March 6, 2018

**RE: Eagle Ranch MVD-Retail (Phase 1: MVD Building)
9651 Eagle Ranch Rd NW (Tract C, Cottonwood Pointe)
Request for Certificate of Occupancy – 30 Day Temporary
Hydrology Final Inspection - Approved
Engineer's Stamp Date 8/22/17 (B13D002C)
Certification Dated: 3/1/18**

**RE: Eagle Ranch MVD-Retail (Phase 1: MVD Building)
Eagle Ranch Rd (Tract C, Cottonwood Pointe)
Request for Certificate of Occupancy – Permanent
Hydrology Final Inspection - Disapproved
Engineer's Stamp Date 8/22/17 (B13D002C)
Certification Dated: 3/1/18**

SHEET NUMBER  
**C-1.0**

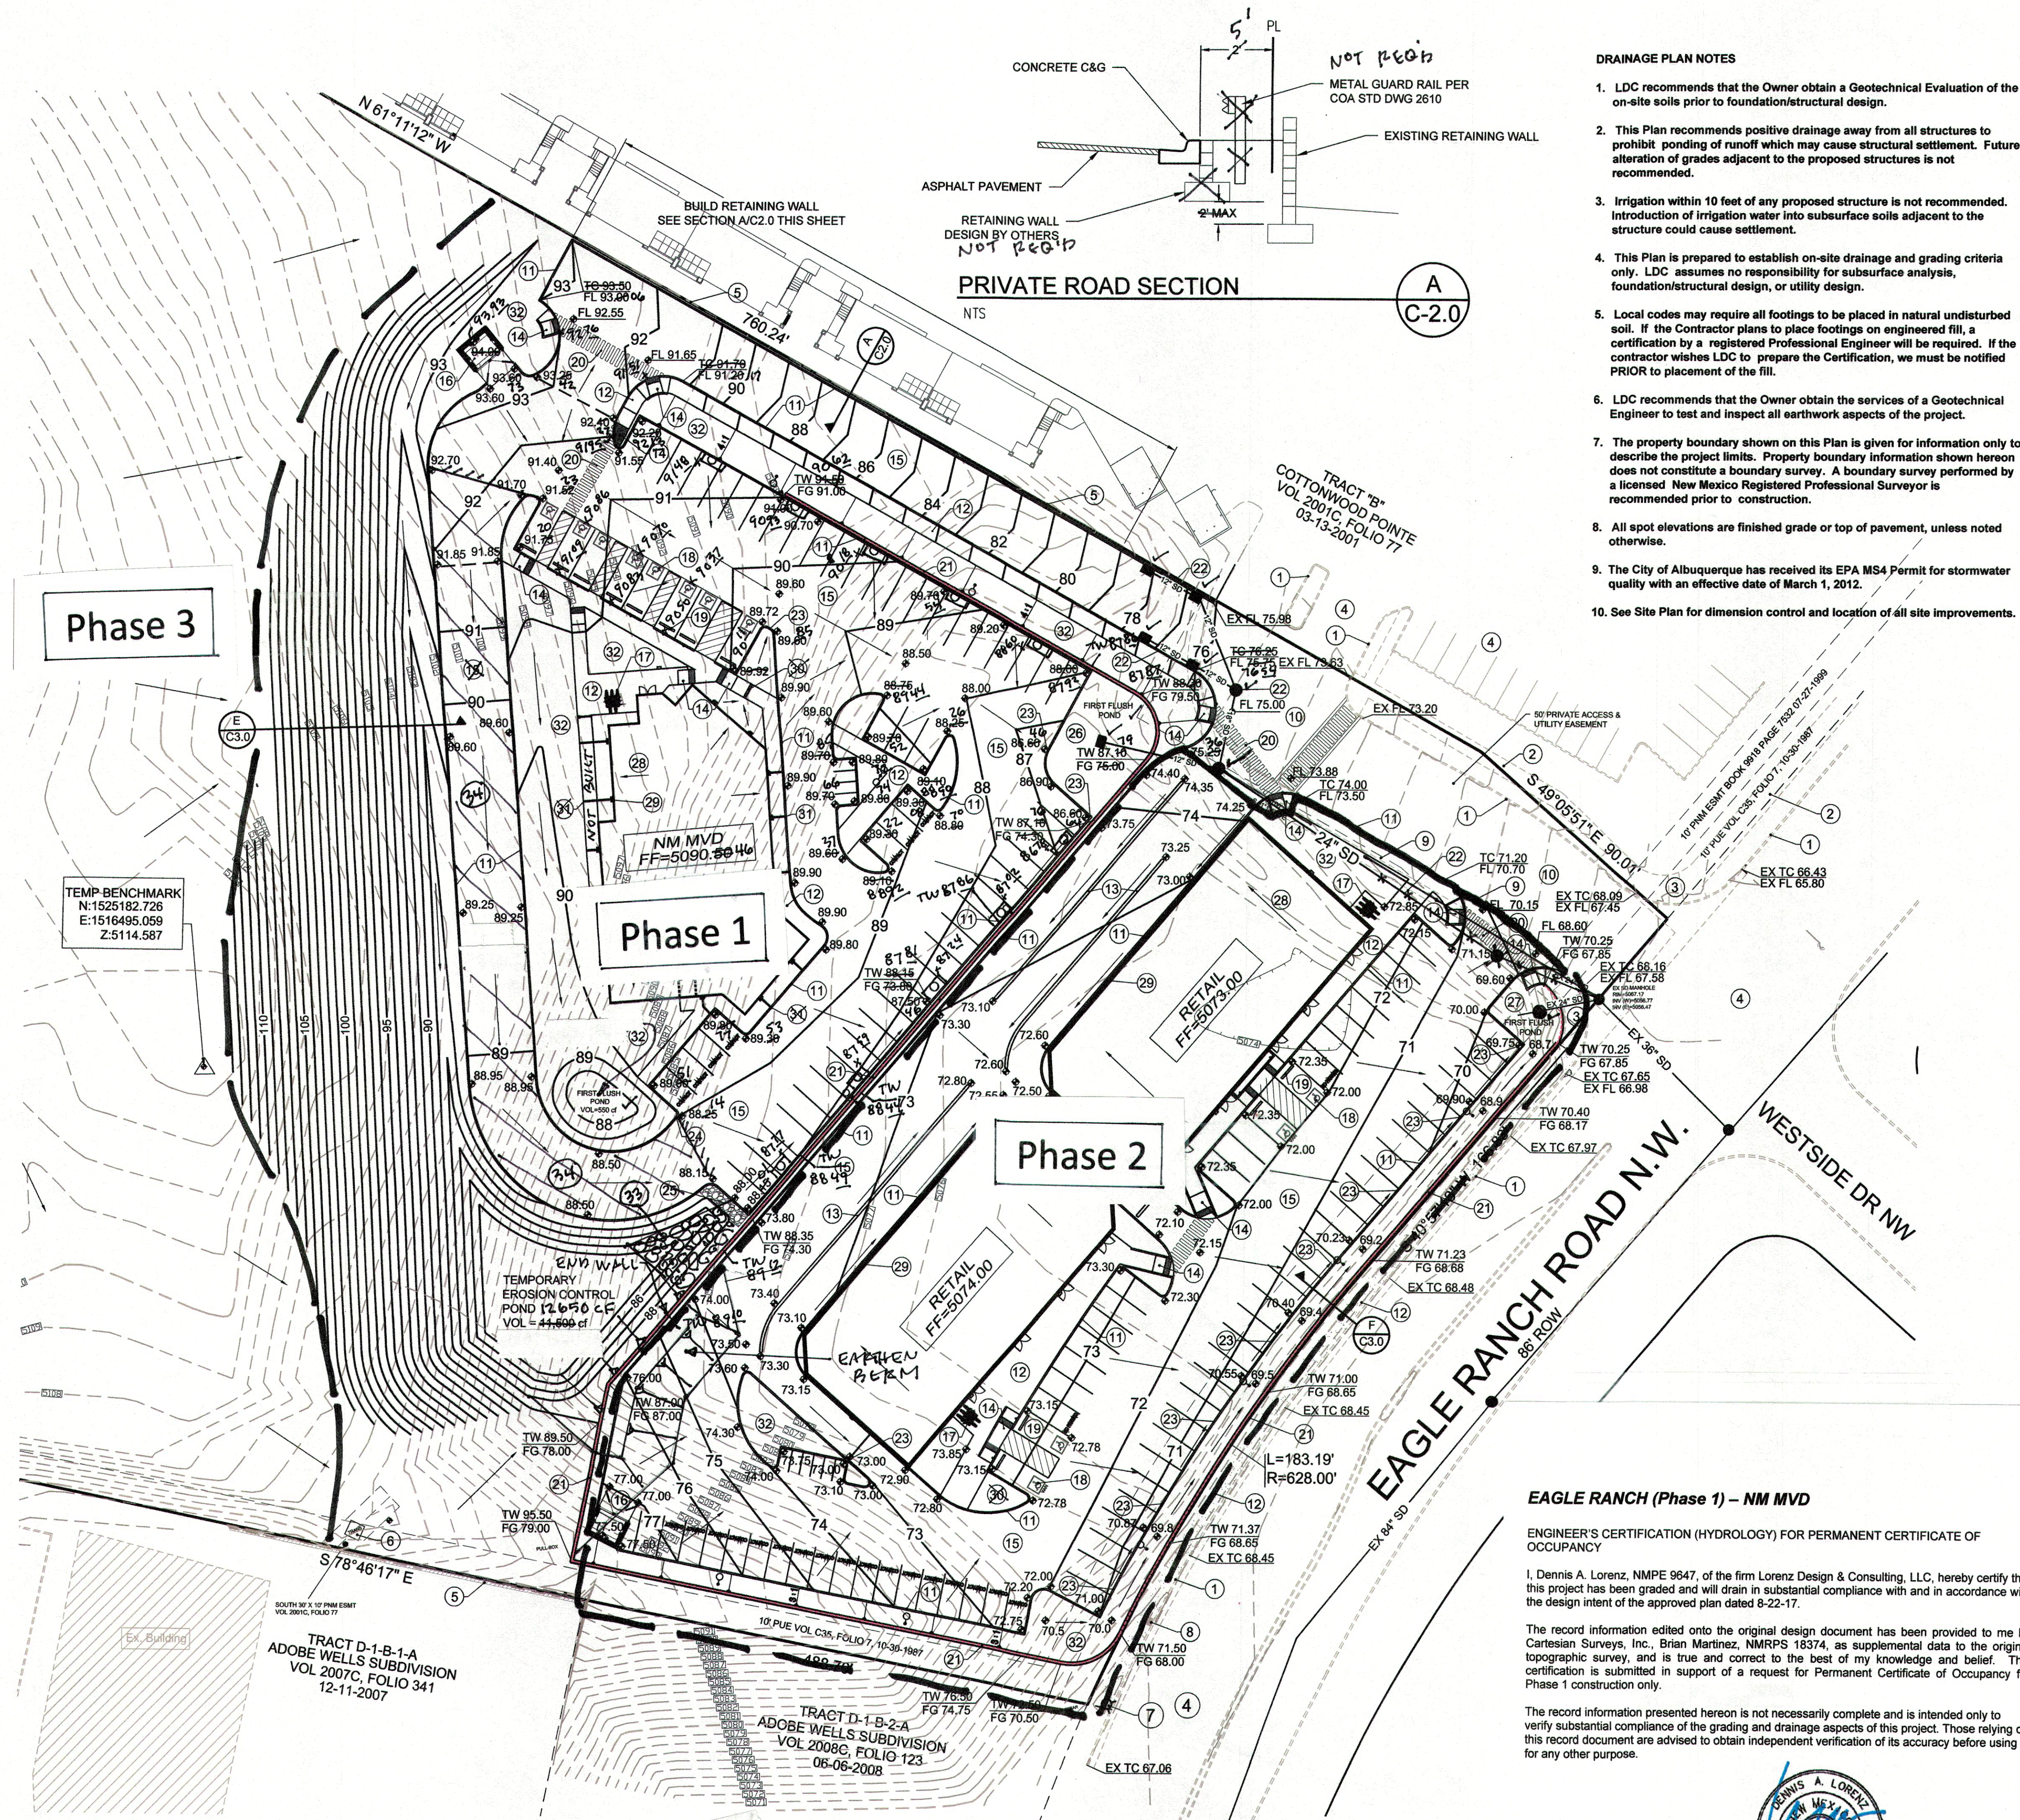
3. The northern edge of the site needs to be regraded and stabilized to prevent cross-lot drainage from crossing onto the adjoining property:

4. Grades need to be restored near the apartment entrance, leaving a cut-bank at property line is not acceptable:

TYPICAL POND SECTION G  
NTS C-3.0

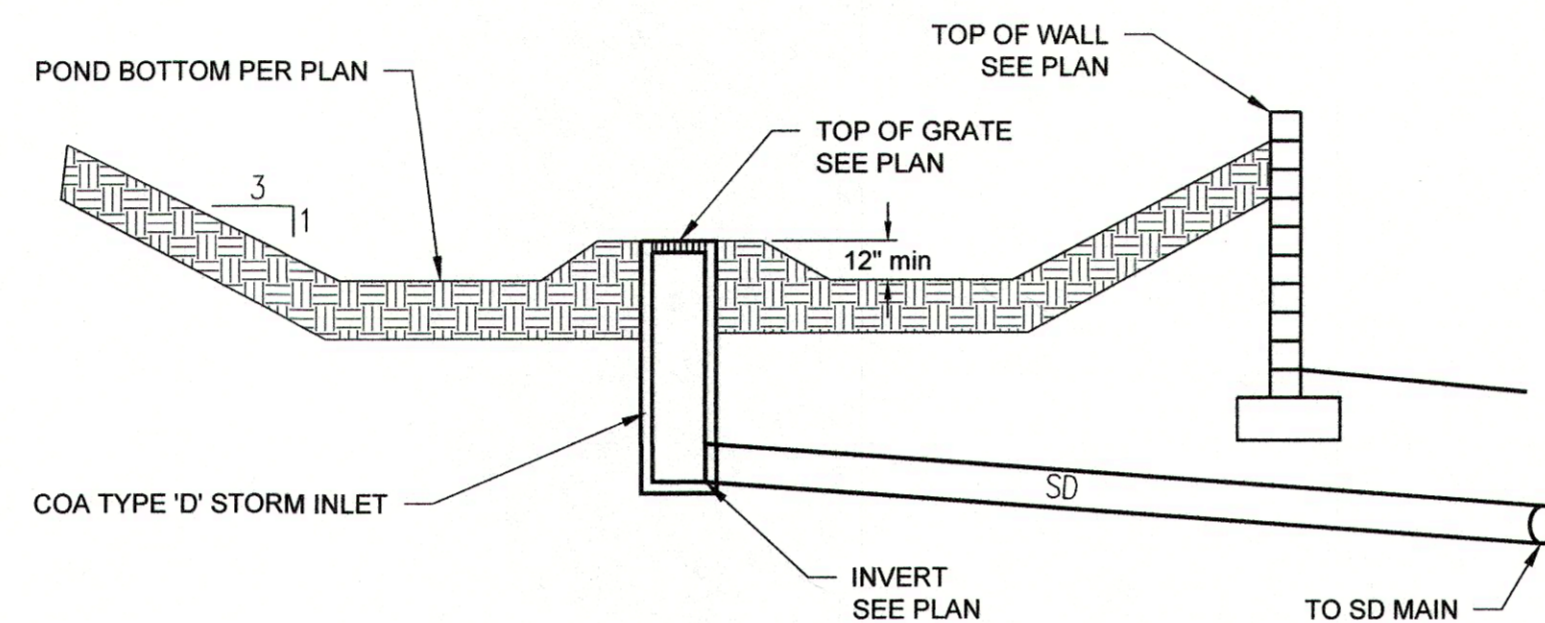
1. First Flush Pond "B" needs to be deepened to 12" below top of grate in order to
provide first flush ponding, per detail G, C-3.0:

OVERFLOW SPILLWAY H  
NTS C-3.0

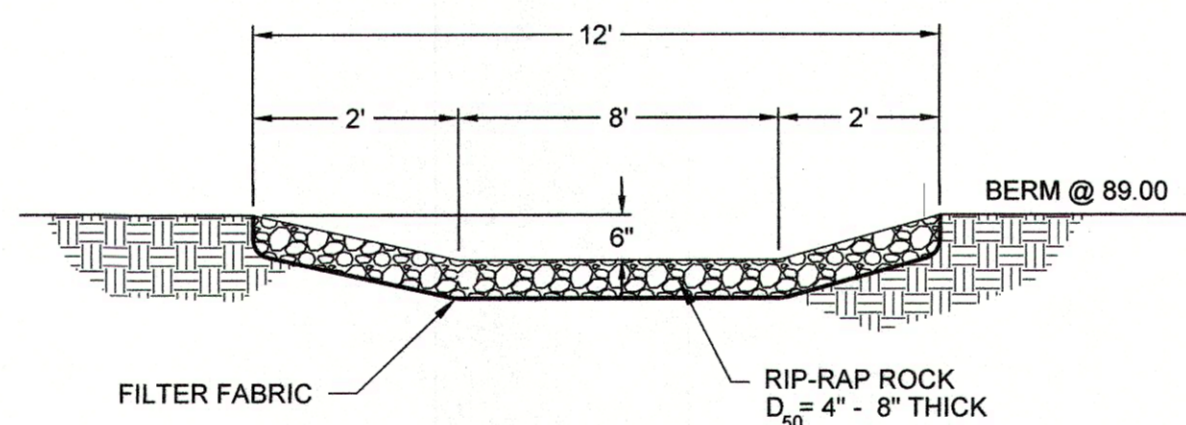
2. The rock for the emergency spillway needs to be replaced with d50=4" rock, per detail H, C-3.0:
